STATE OF NORTH CAROLINA  
DEPARTMENT OF TRANSPORTATION

March 22, 2013

**Subject:** Request for Modifications to the Section 404 Individual Permit and Section 401 Water Quality Certification for I-485 (Charlotte Outer Loop) from east of I-77 to I-85 in Mecklenburg County. Division 10, TIP's R-2248 E and R-2123 CE, Debit \$570 from WBS 34410.3.GV2

**Reference:** USACE Individual Permit Action ID SAW-2011-01237, dated Nov.22, 2011.  
NCDWQ Water Quality Certification No. 003868, dated October 14, 2011.  
NCDOT Modification Application dated June 4,2012  
NCDWQ Water Quality Certification Modification dated Jun 21, 2012

Permit Drawing  
Sheet 51 of 108

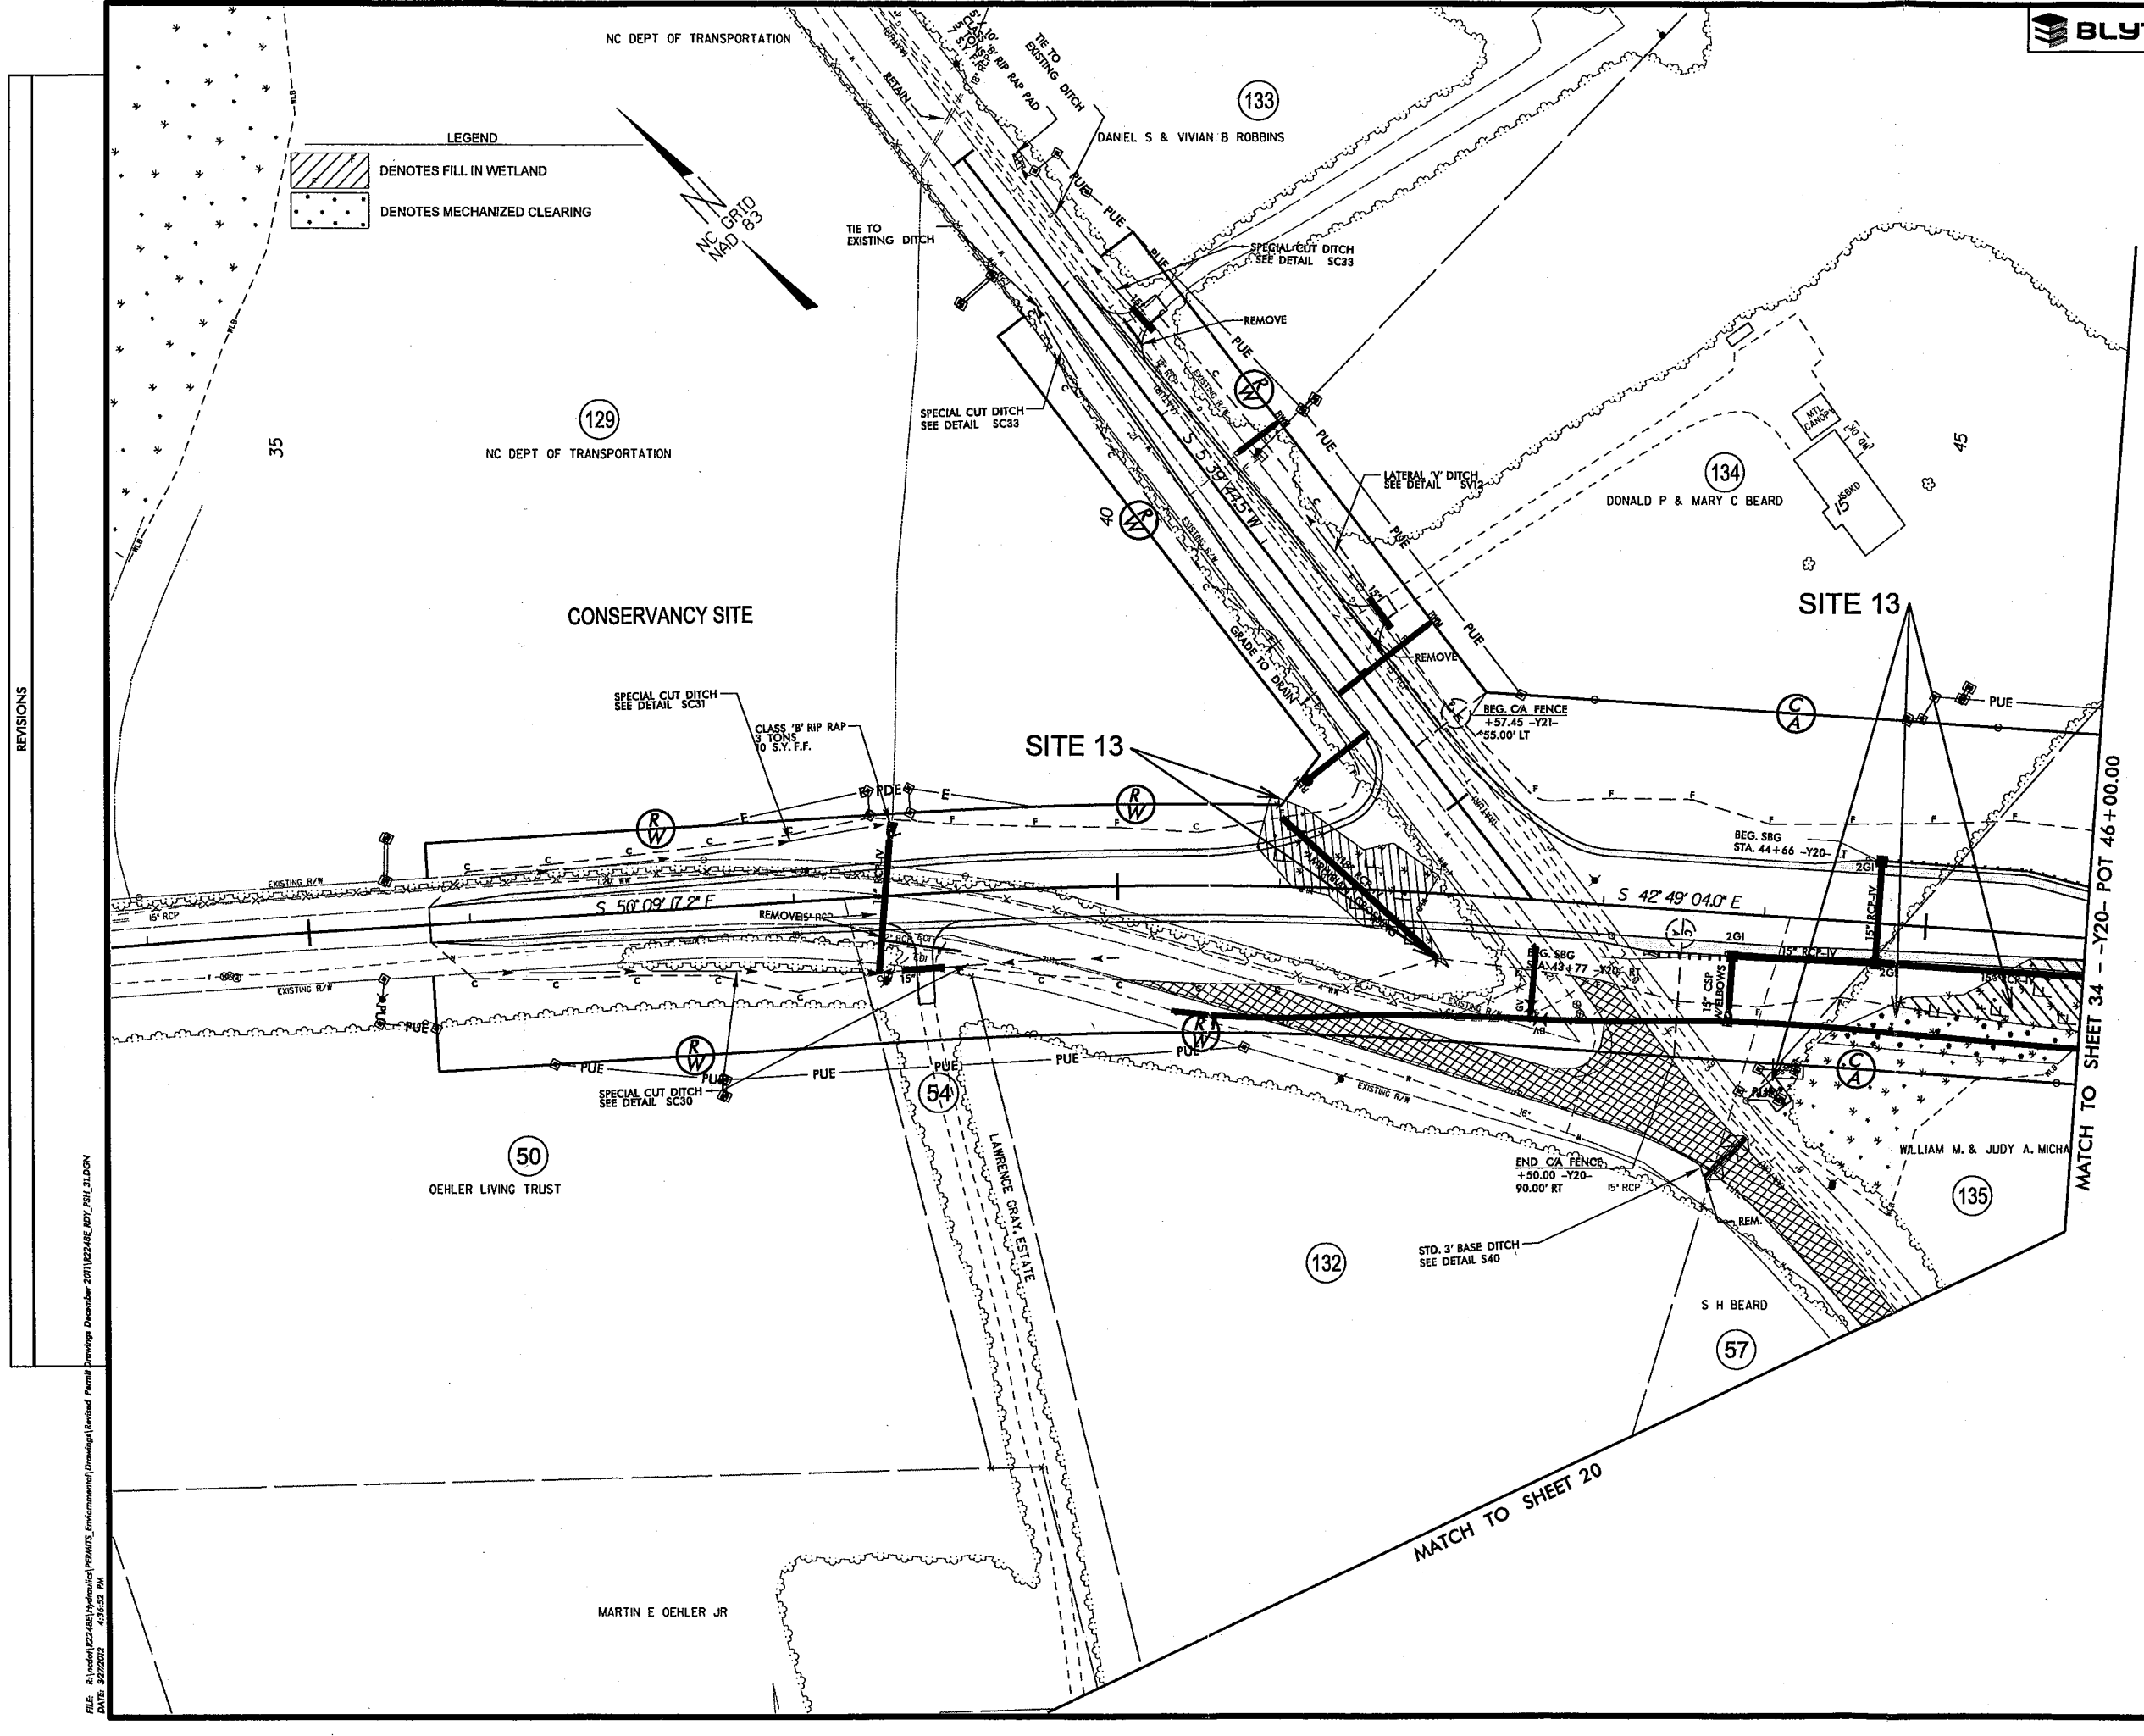
**Revision:** An increase in impacts from 0.03 to 0.12 acre of mechanized clearing (+0.09 acre wetland)  
An increase in impacts from 0.0 to 0.03 acre of excavation (+0.03 acre wetland)  
Note – increased impacts at this site are to non-riparian wetlands.

**Reason:** Water line and utility pole guy-wire anchors added, south of Y22.

Permit Drawing  
Sheet 48 of 108

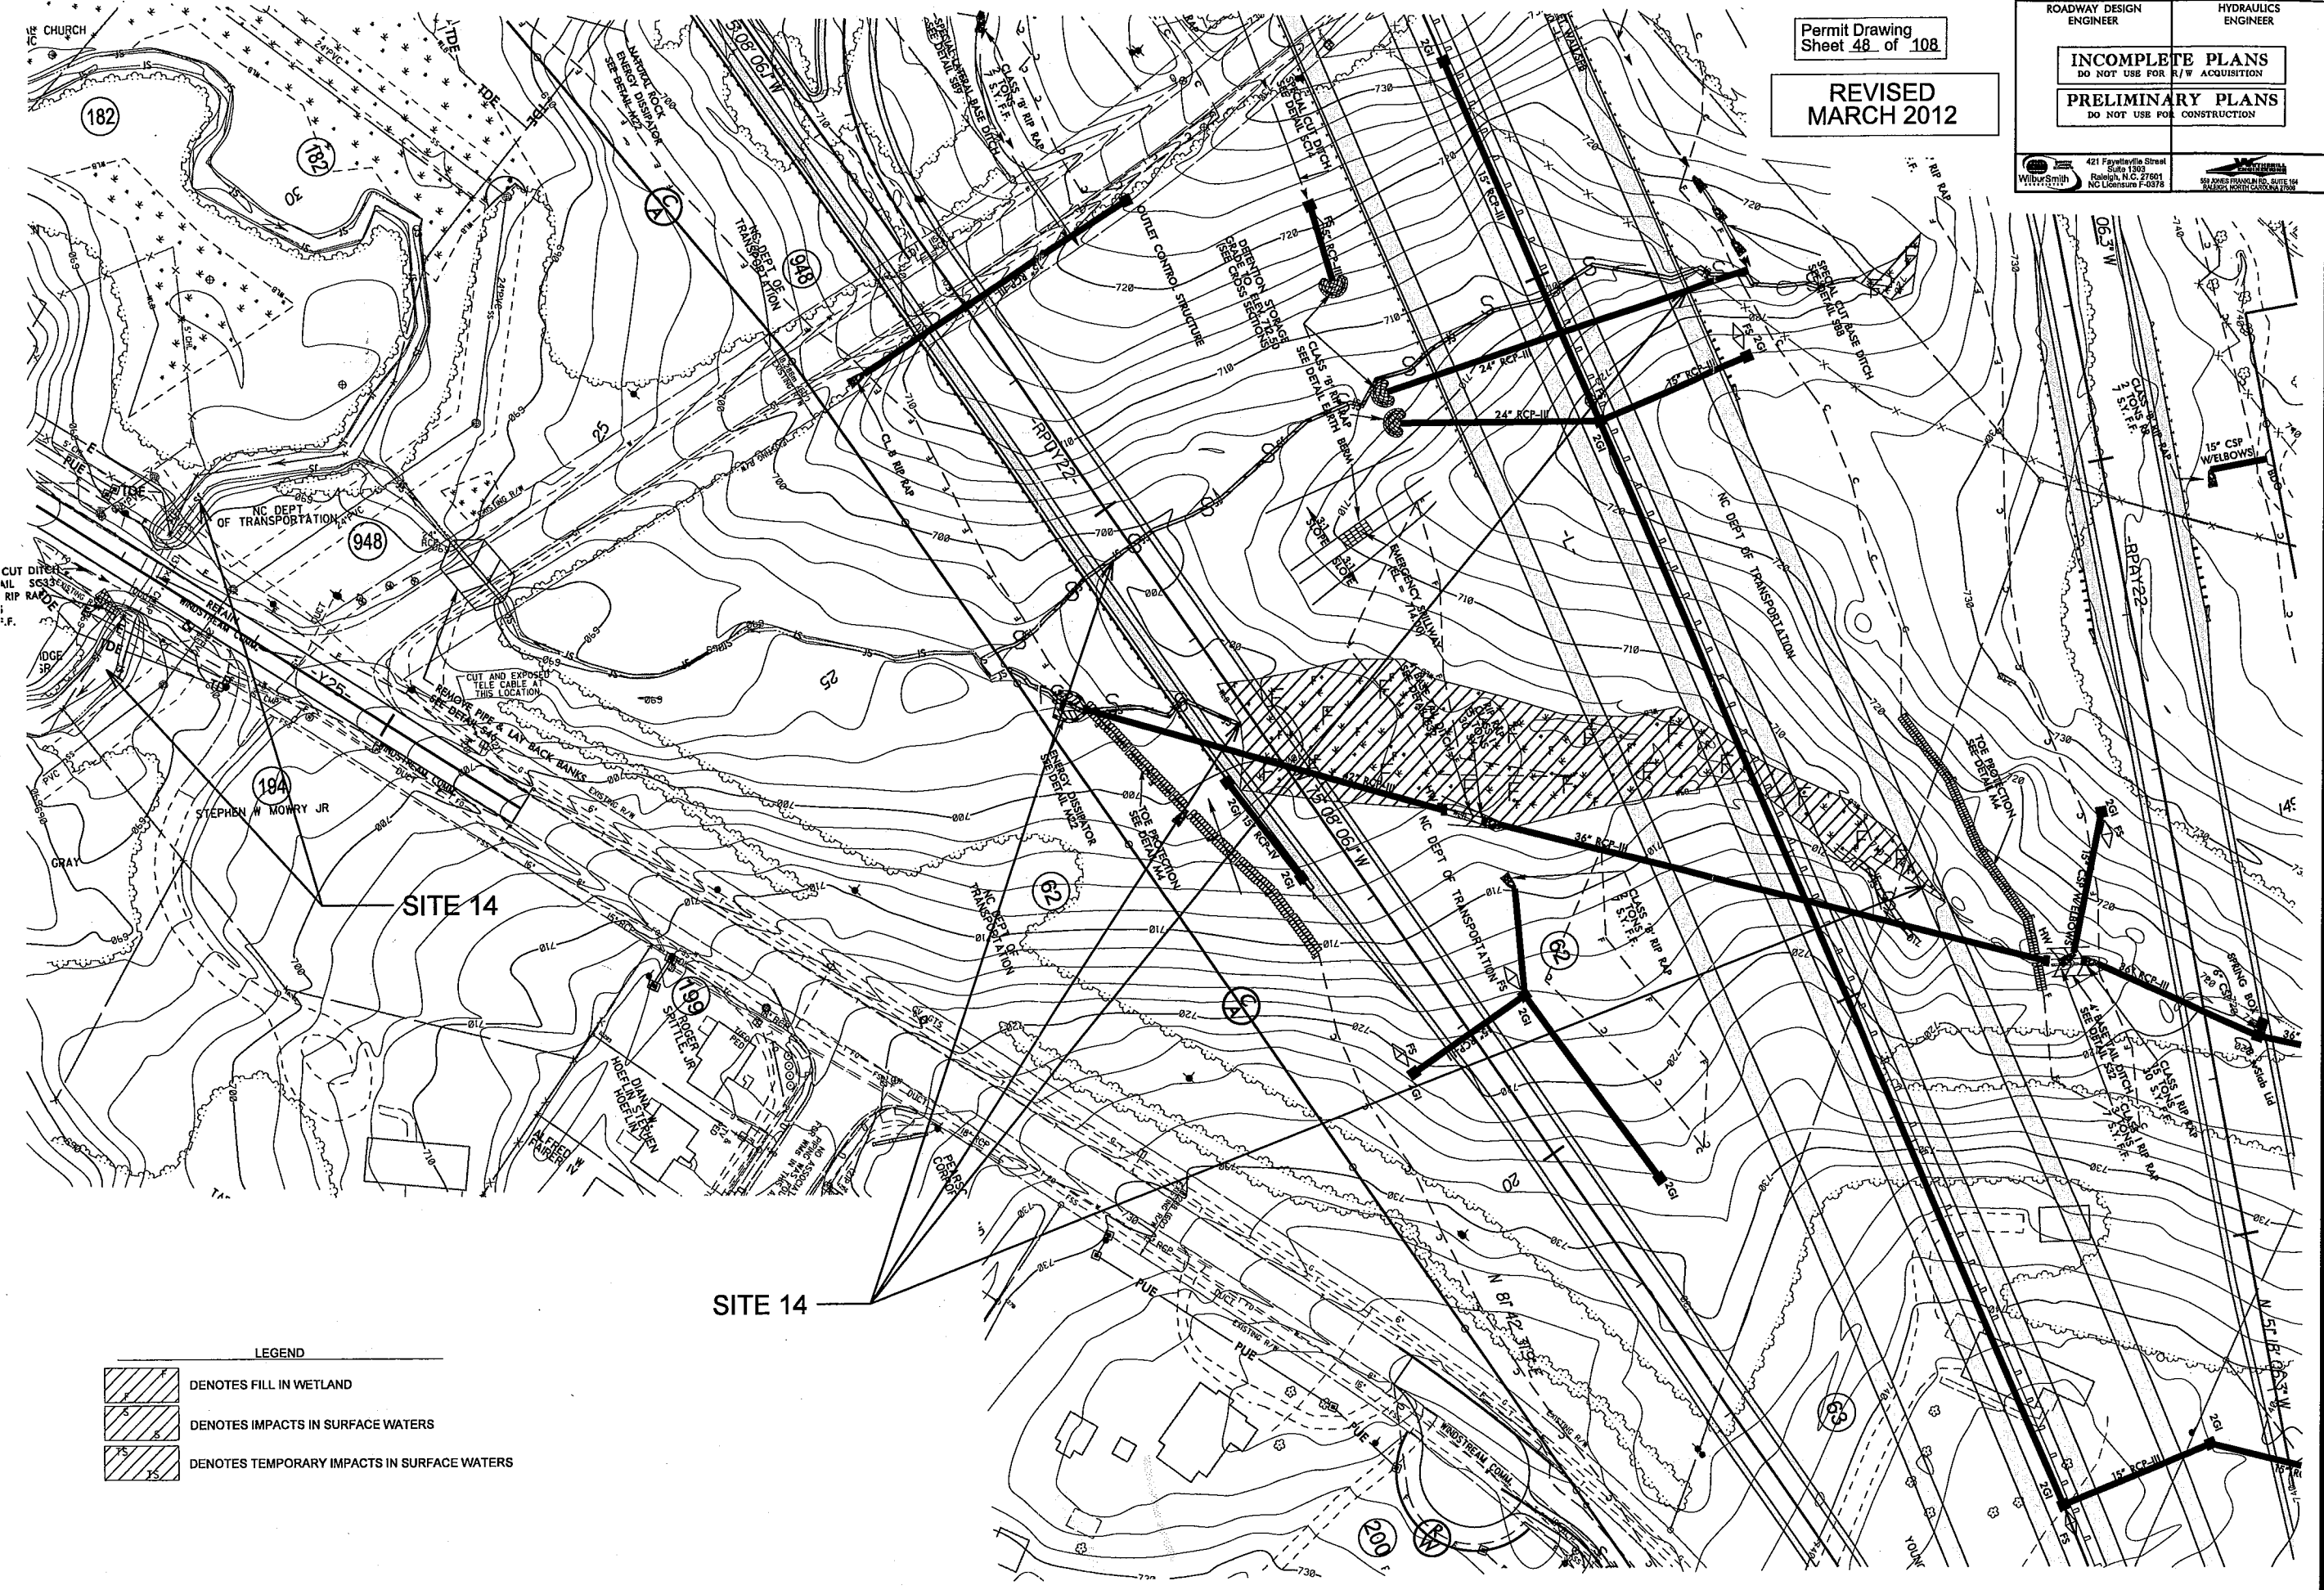
**Revision:** Elimination of 2 @ 7' x 8' RCBC (replacement)  
Reduction in impacts from 0.617 to 0.596 of fill (- 0.021 acre riparian wetland)  
Reduction of 35 feet BS (-35 feet BS)  
Temporary impacts have decreased from 57 linear feet to 0 (-57 linear feet)

**Reason:** The project no longer includes this stream crossing.

Permit Drawing  
Sheet 53 of 108

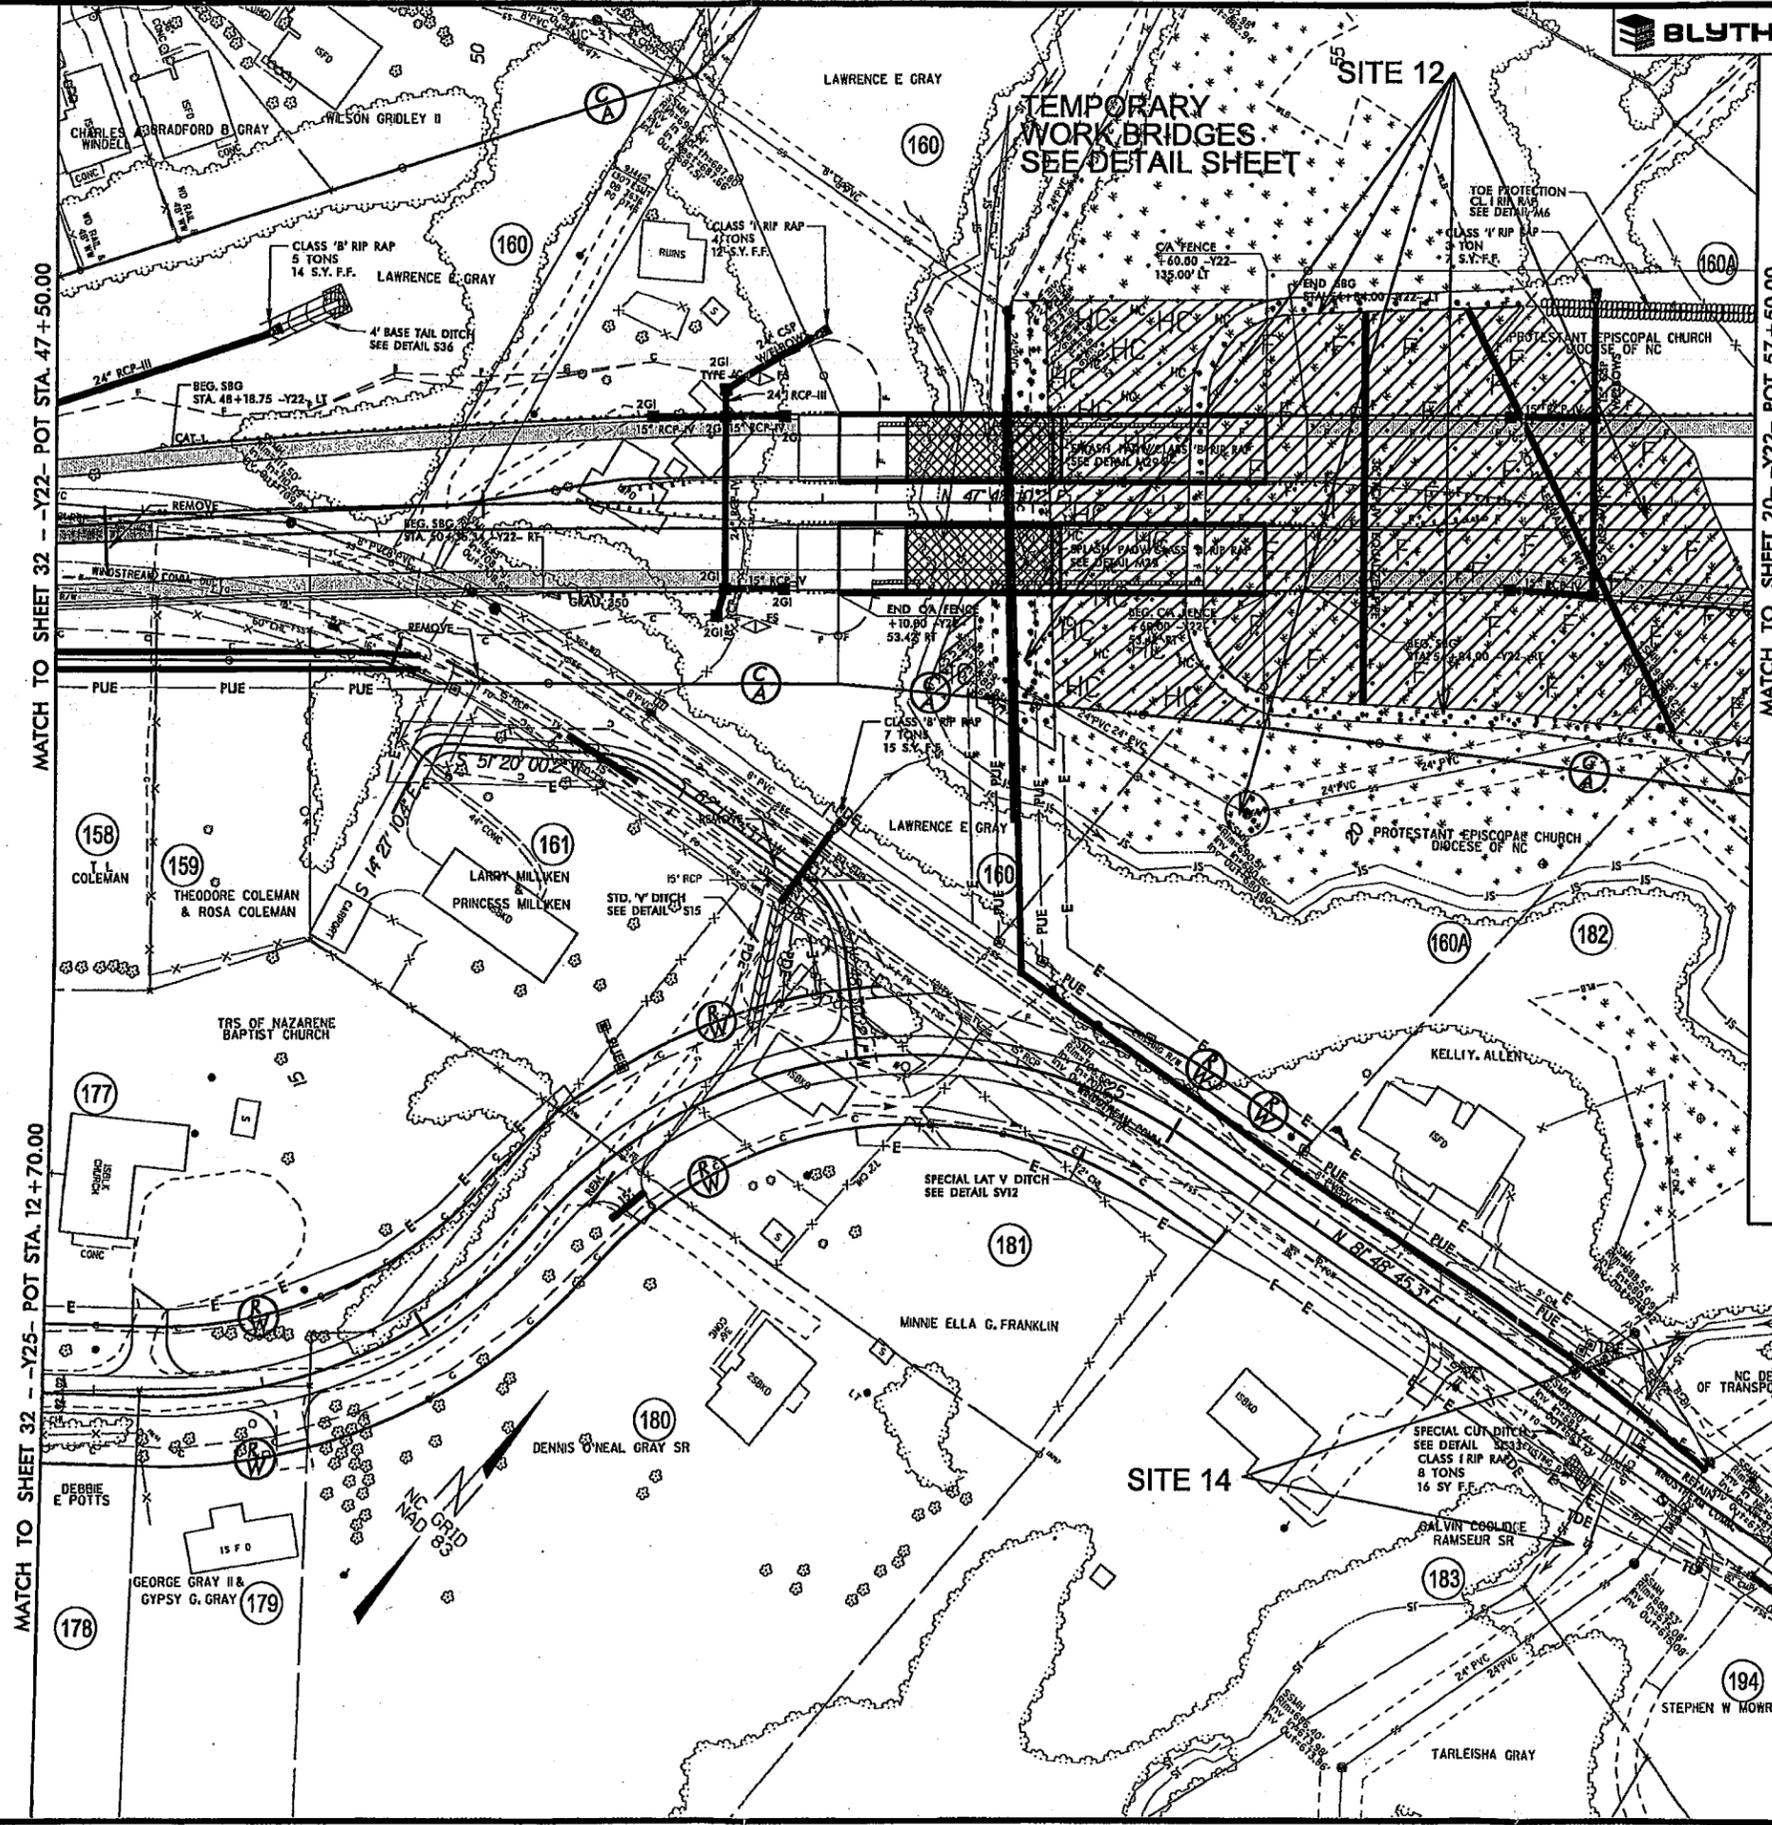
**Revision:** An increase in impacts from 0.164 to 0.799 acre of mechanized clearing (+0.635 acre riparian wetland)  
An increase in impacts from 0.0 to 0.262 acre of excavation (+0.262 acre riparian wetland)  
A decrease in impacts from 0.612 to 0.497 acre of hand clearing (HC) (-0.11 acre riparian wetland)  
Note- the HC area will now be considered for mitigation due the change in the wetland type/function.

**Reason:** A new sewer line will cross portions of Wetland WBA increasing the excavation and mechanized clearing impacts – this sewer line was re-routed due to constructability issues.
